Date: 10/28/2022

Re: **Framing Item**
Location: Lot 115 The Farm at Neill's Creek (Lillington, NC)
JDS Project No.: RDU2211163
Date of Inspection: 10/28/2022

DRB GROUP	
MIDDLETON 2 - 115 FARM AT NEILLS CREEK	
ROOF TRUSS LAYOUT

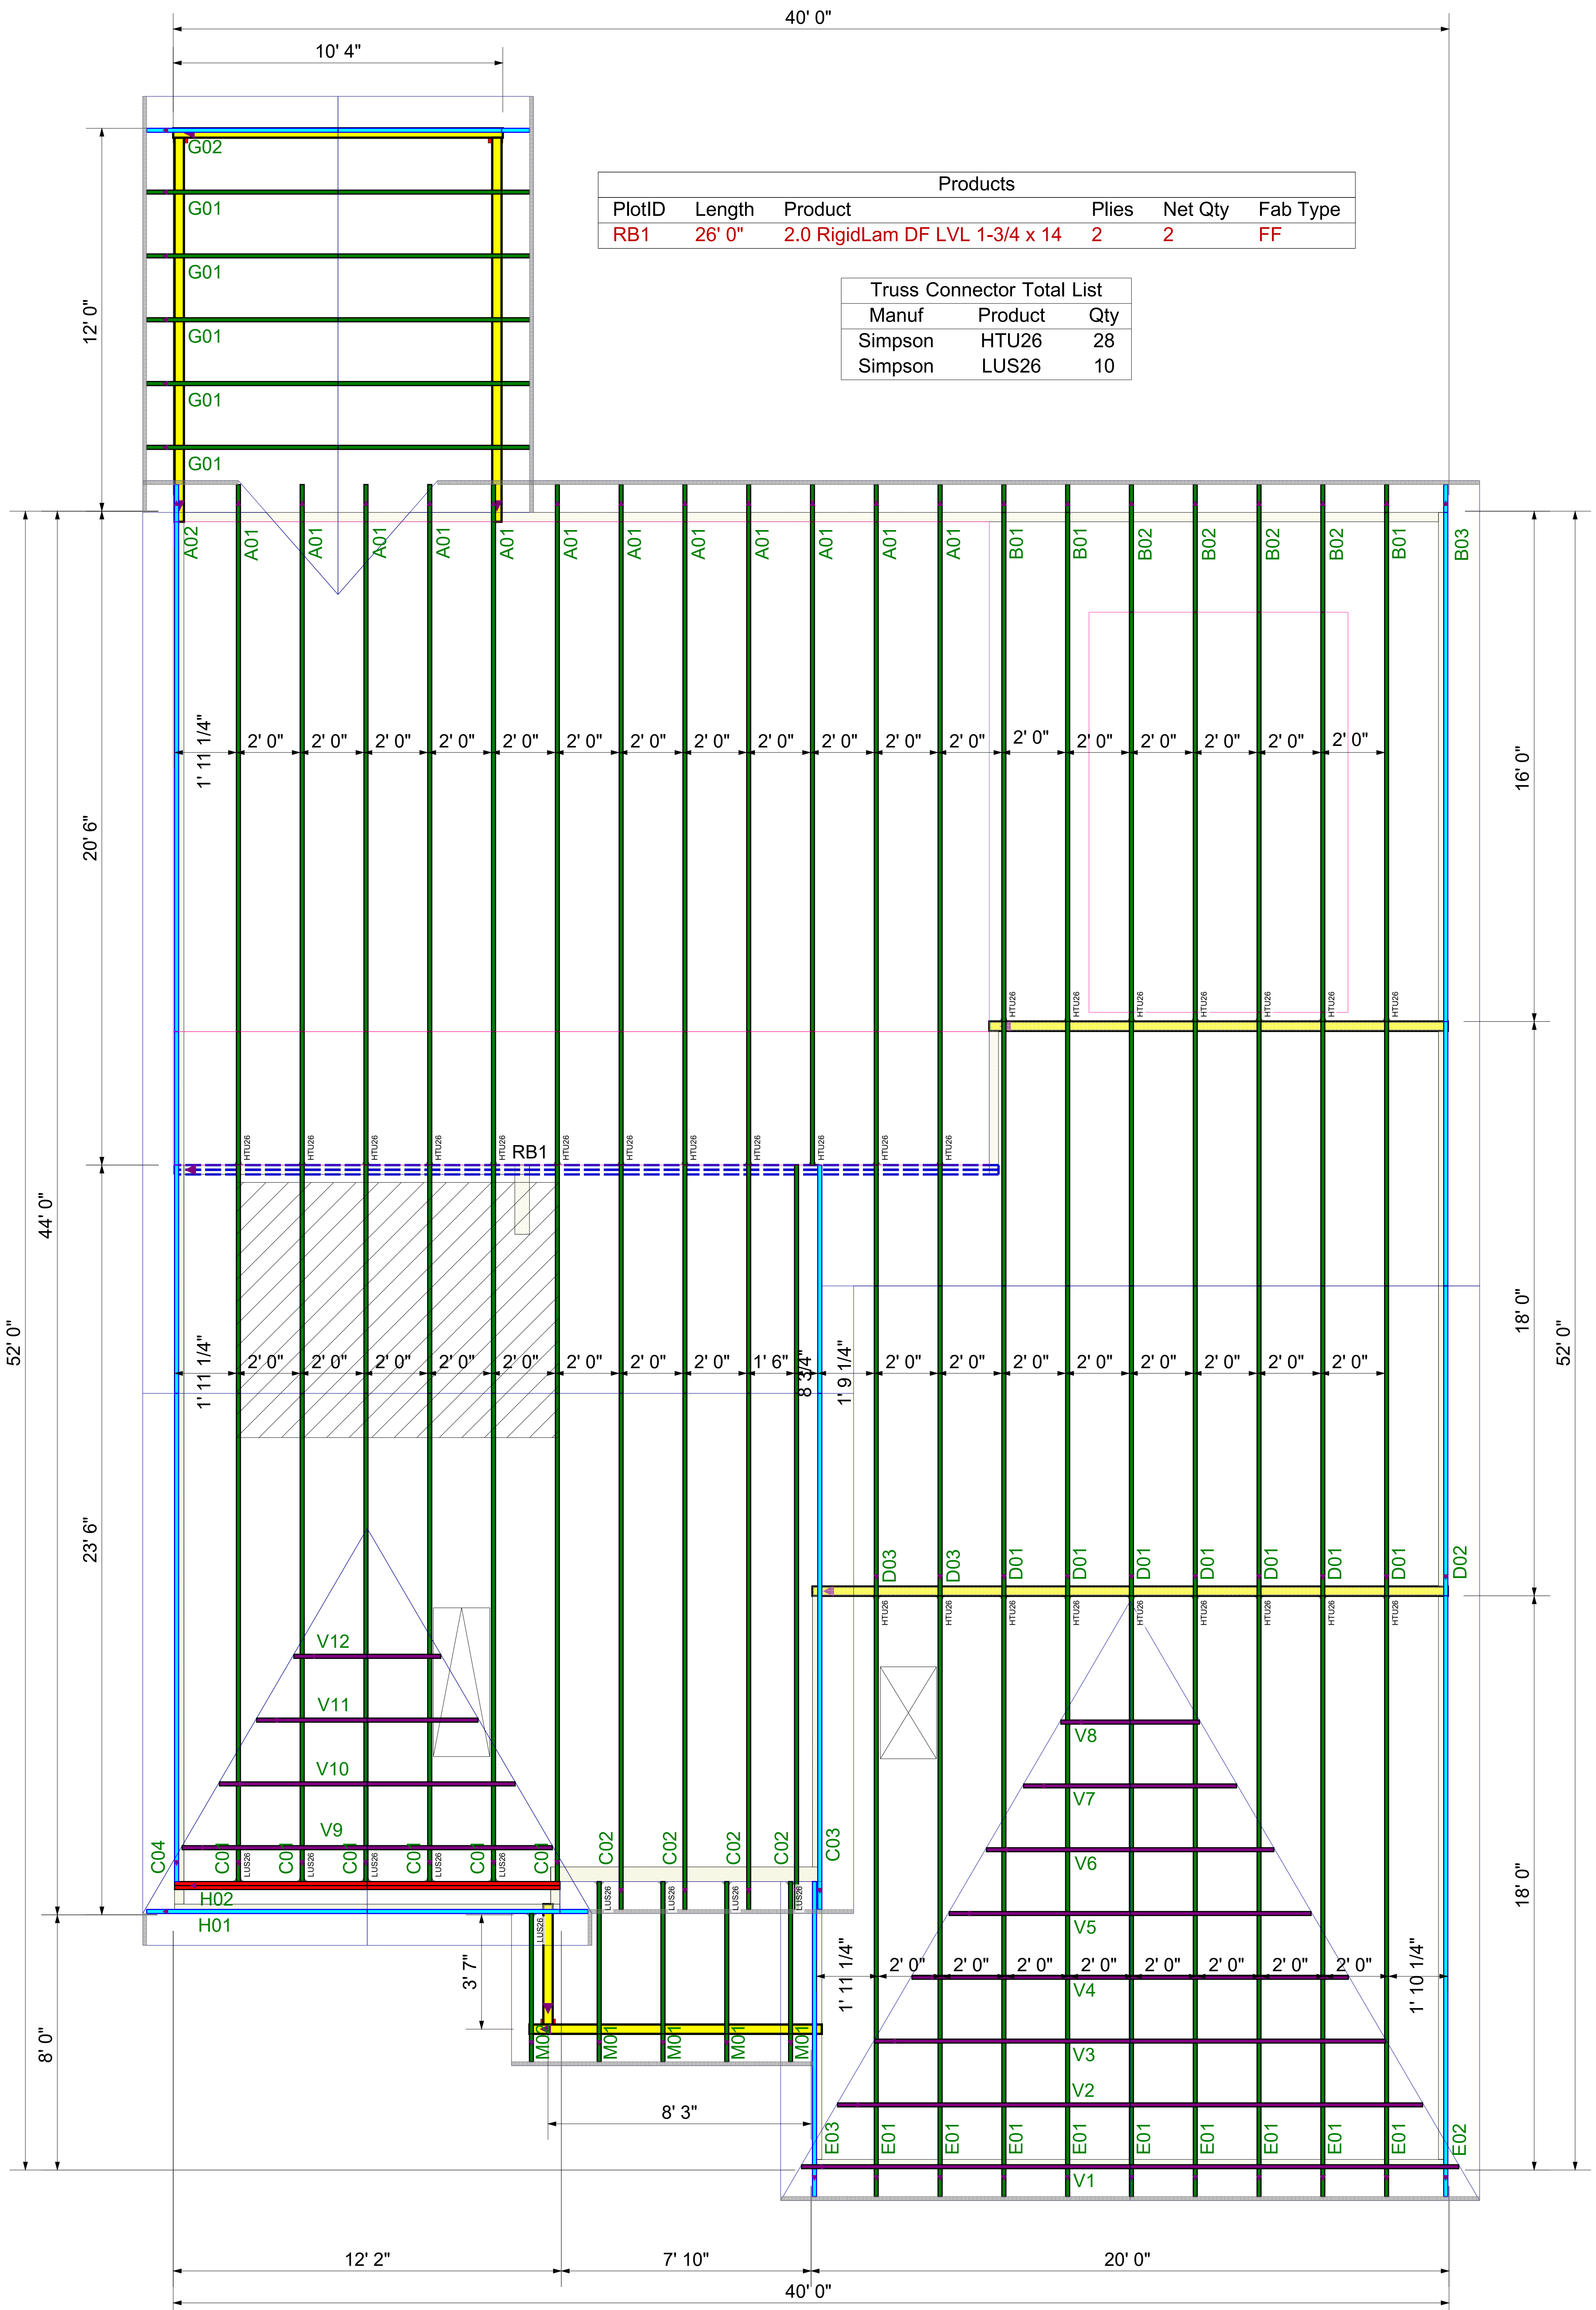
The plan calls for the roof sheathing **not** to be spliced within 12" of the rear wall of bedroom 4. As built the sheathing splice is within 12" of the wall. It has been repaired with 2x4 scabs on each side connecting the top and bottom trusses and with 2x6 blocking toenailed into the adjacent trusses at the roof sheathing splice for the length of the wall.

Based on our onsite observations and review, the repairs are adequate. No further repair is required.
